Project Name:	Land at Bayards, Eastergate (Miller Homes)
Document Reference:	091.5016/SVR/7
Document Name:	SuDS Verification Report – Area 7
Prepared By:	Samuel Flesher
Checked By:	Meagan Weedon
Approved By:	Jon Soar

- 1.1 This Sustainable urban Drainage Strategy (SuDS) Verification Report – Area 7, has been prepared by Paul Basham Associates on behalf of Miller Homes to support the 'As-Built' verification report to Arun District Council in relation to Land at Bayards, Eastergate.

- 1.2 This Verification Report has been prepared to support the discharge of Planning Condition 24. The report authors are Paul Basham Associates Ltd. Paul Basham Associates were established in 2009 and are a multi-disciplinary Transport Planning, Civil and Structural Engineering Consultancy, employing a team of Civil Engineers.

PBA Drawing No. 091.5016.0501 Revision C08

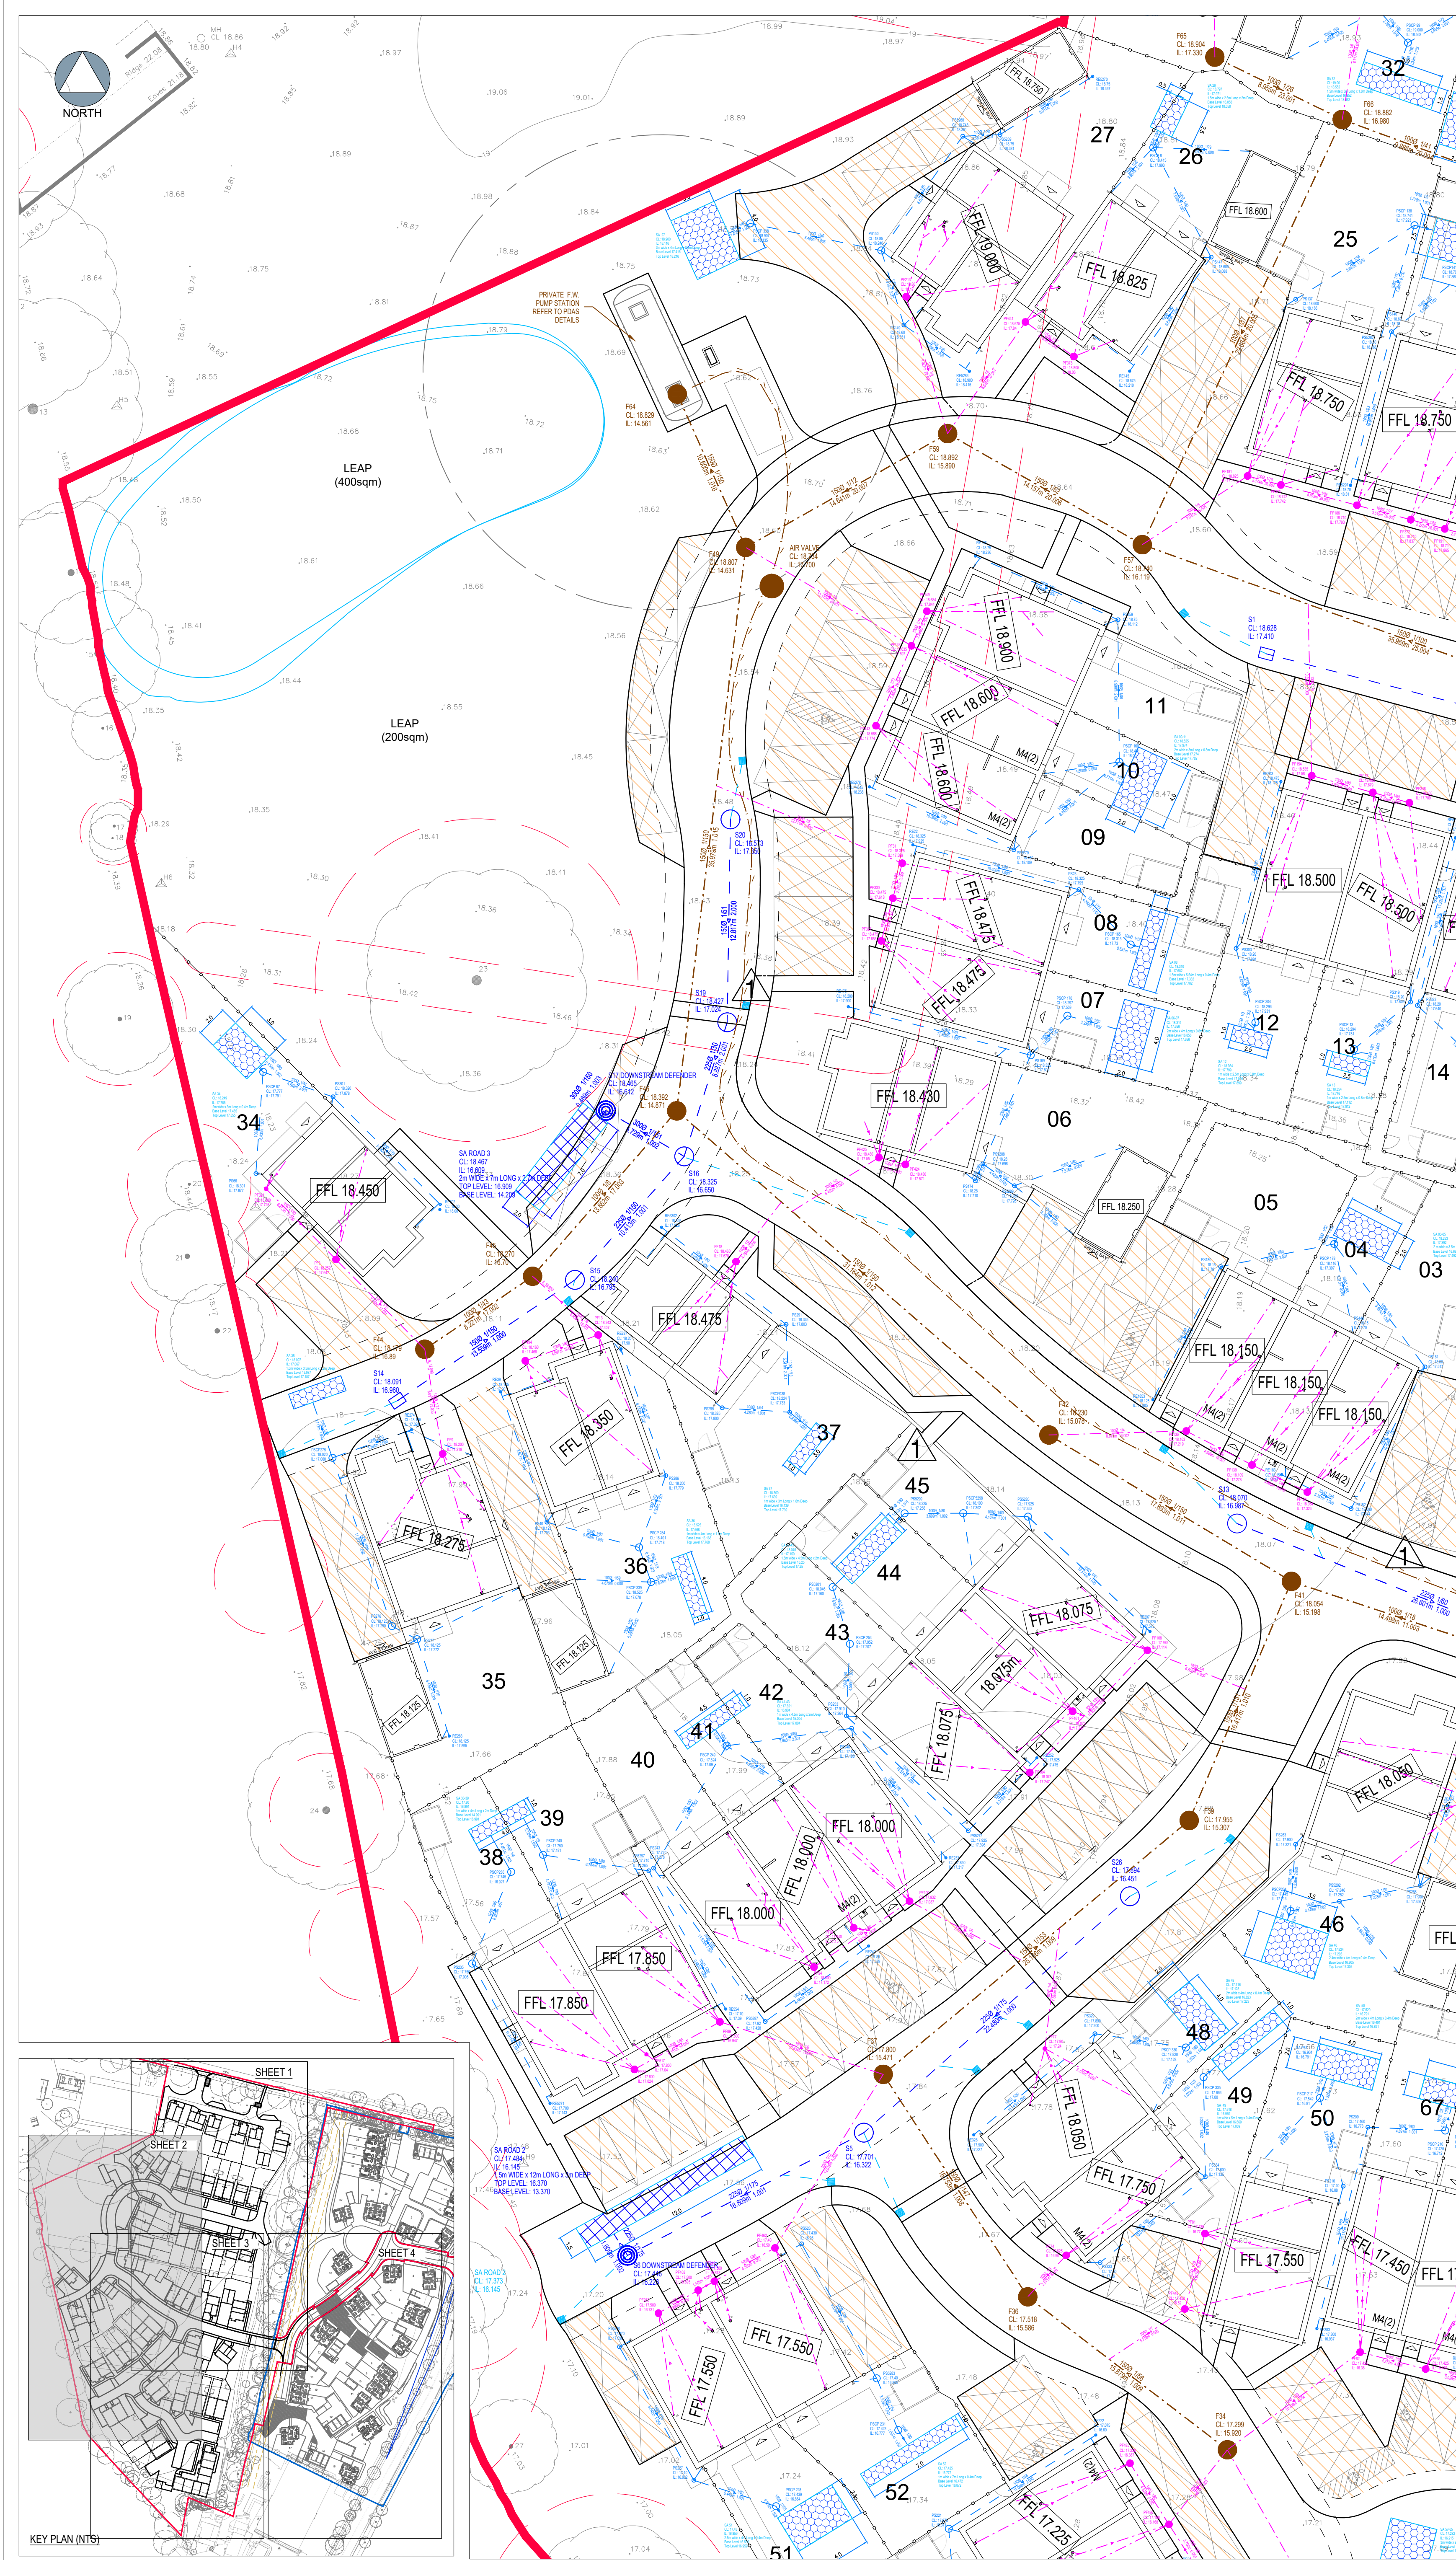
- 3.1 As-Built surveys of the site area and drainage systems have been carried out and the surveys are included as **Appendix C**.
- 3.1 These levels have been reviewed against the design levels shown in 091.5016.0501 C08, 091.5016.0502 C05 and 092.5016.0503 C06 the design drawings can be found in **Appendix B**
- 3.2 A tabulated summary of invert levels for chambers constructed within Area 7 is given below.

- 3.3 The comparison between the design and as built levels shown that the invert levels are generally within normal building site tolerances.
- 3.4 Cross checks of raised invert levels appear to show that no backfalls have been created.
